**Harnett County**  
420 McKinney Pkwy

**SUBJECT: SFD2208-0061**  
**SINGLE FAMILY DWELLING**

Here are the results of all Inspections located at **5210 OLD US 421:**

FOUNDATION PLAN

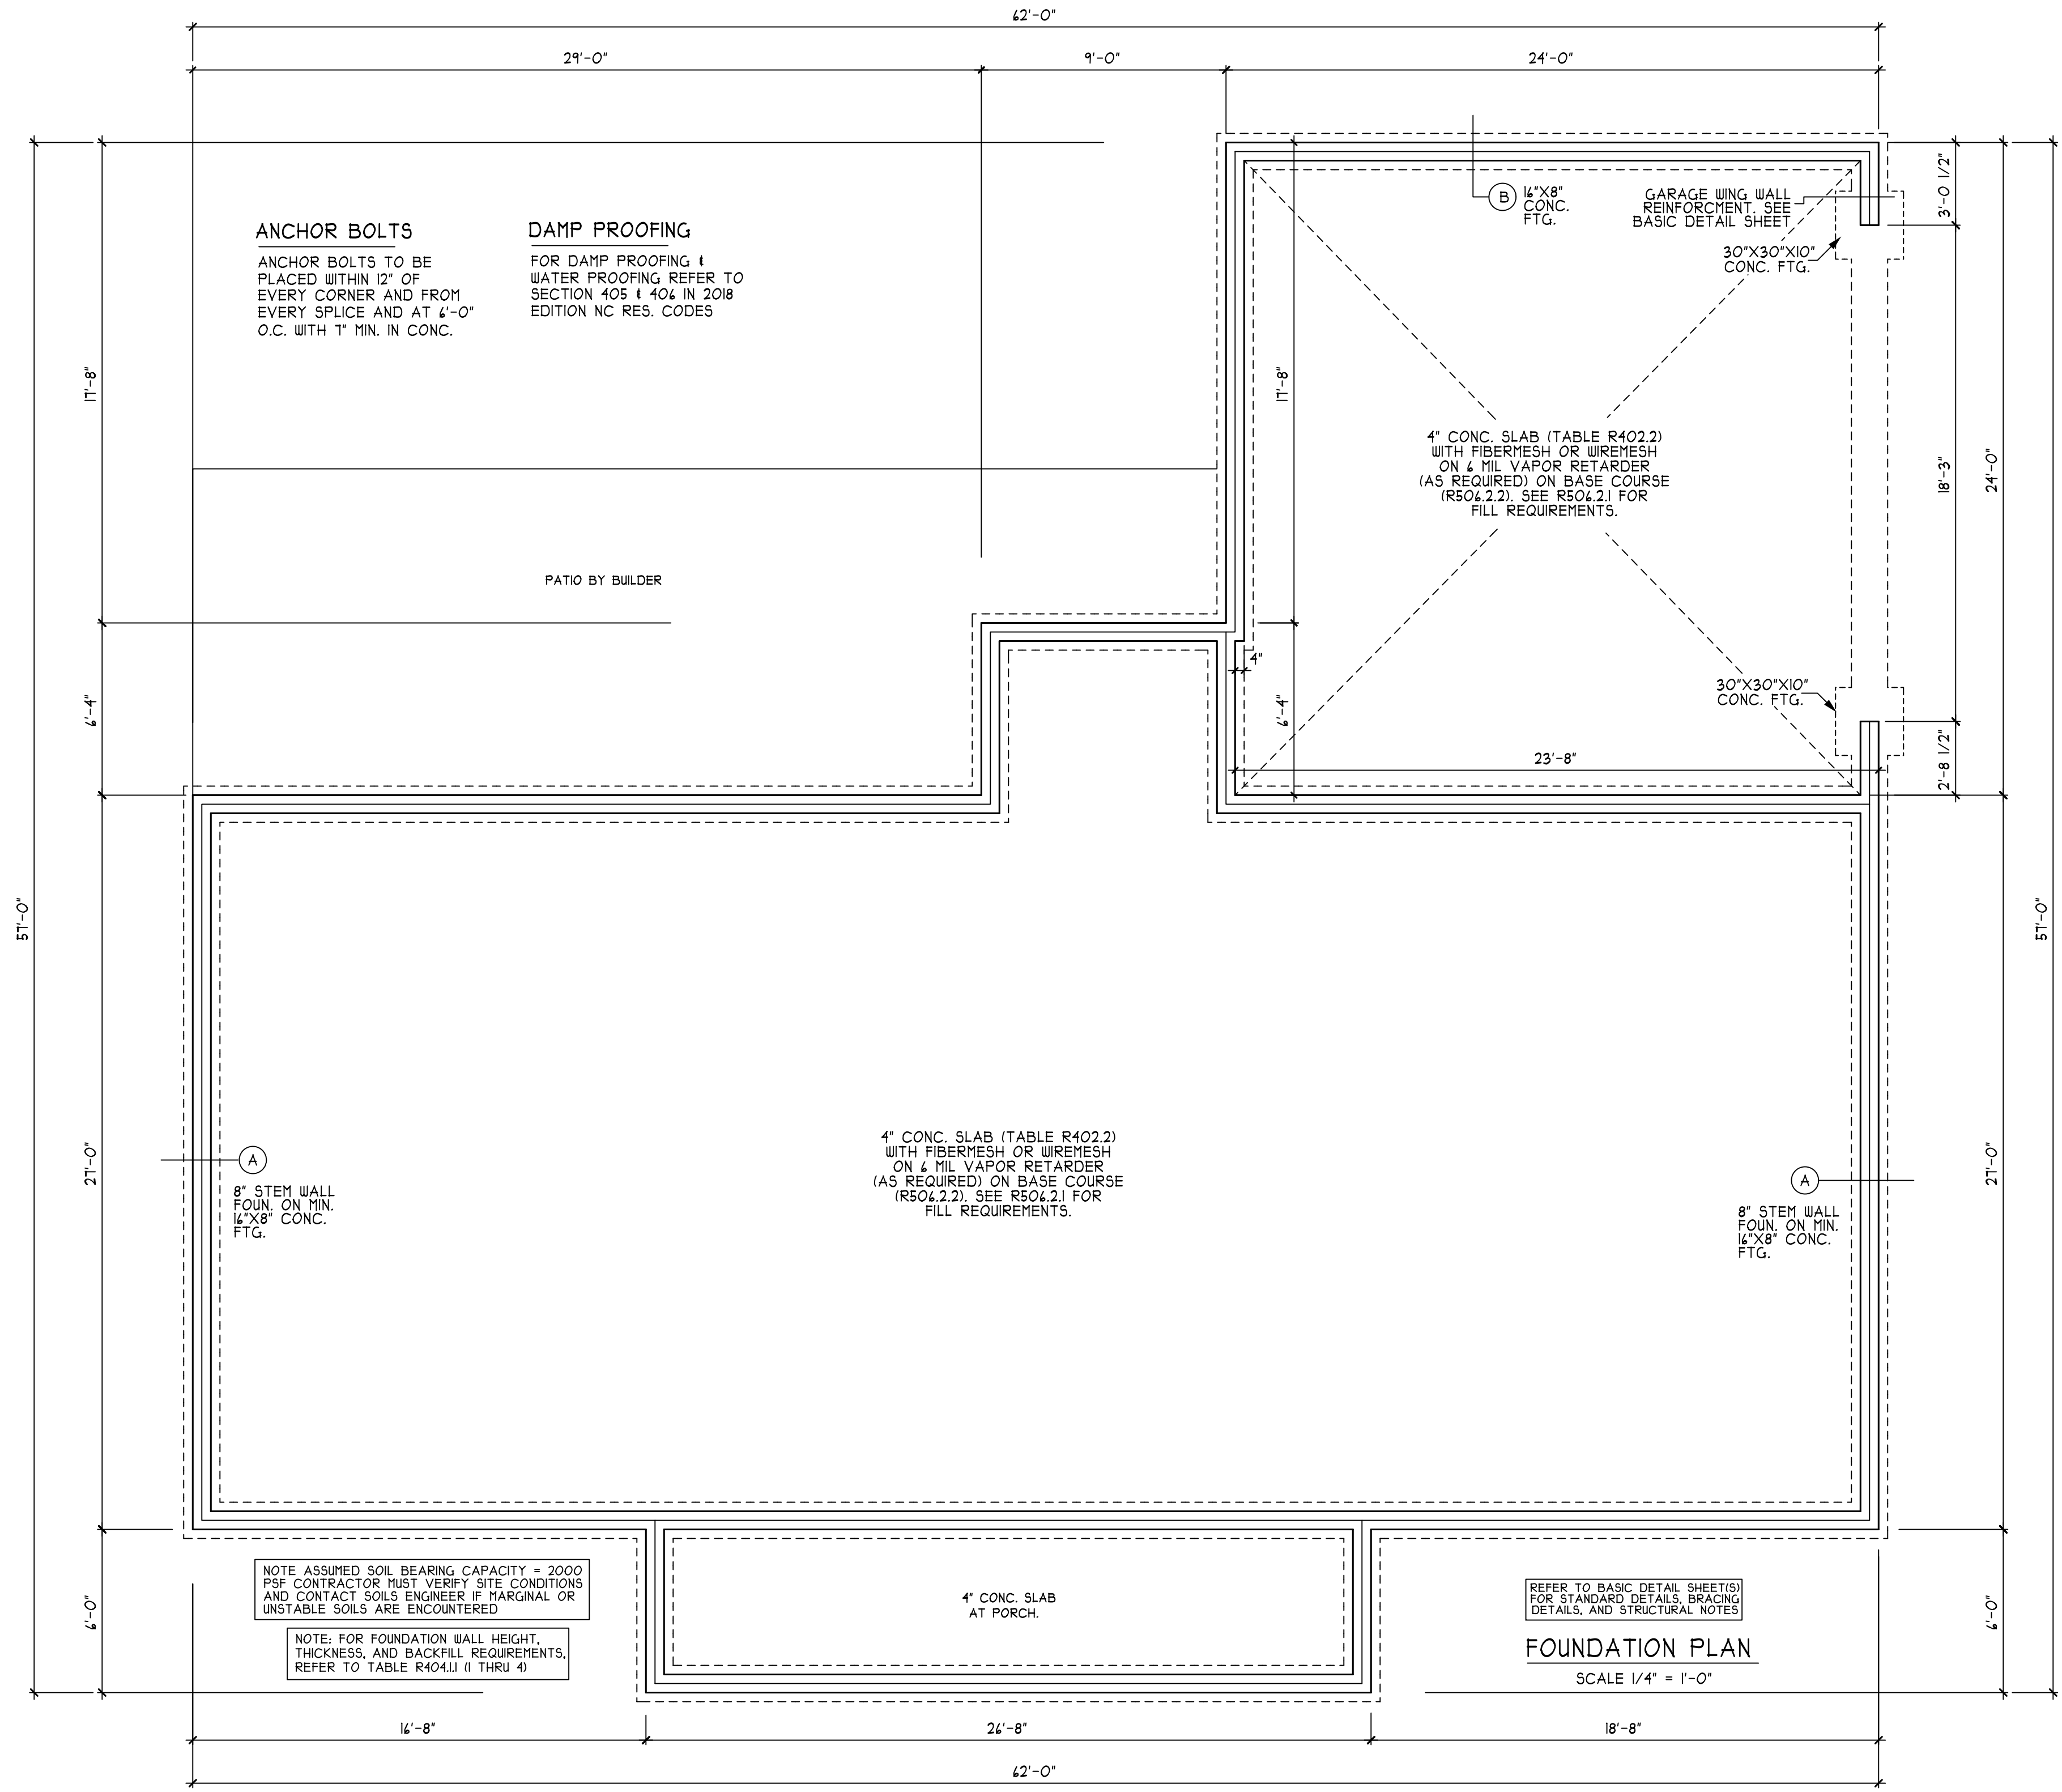
Missing anchor bolts, need two per plate and 12 inches from corner of house. Missing garage wing wall 2" square washers. Add cripple stud under plate break above garage door. Plumbing pressure test down. Seal top of laundry wall. Missing toilet flanges. No plumbing drain test. Seal pipes to slab at tub. missing insulation stops and baffles. Missing porch post and attachment. Tape vertical seems of housewrap.

Inspection Type: ROUGH IN REINSPECT  
Scheduled Date/Time: 10/9/2023  
Completed Date/Time: 10/9/2023  
Inspector: John B Kokoszka  
Result: DISAPPROVED  
Remarks:  
Notes: Missing portal framing bolts and 2x2 washer at garage Need 100 psi on water line testMissing front porch connection. All from previous inspection
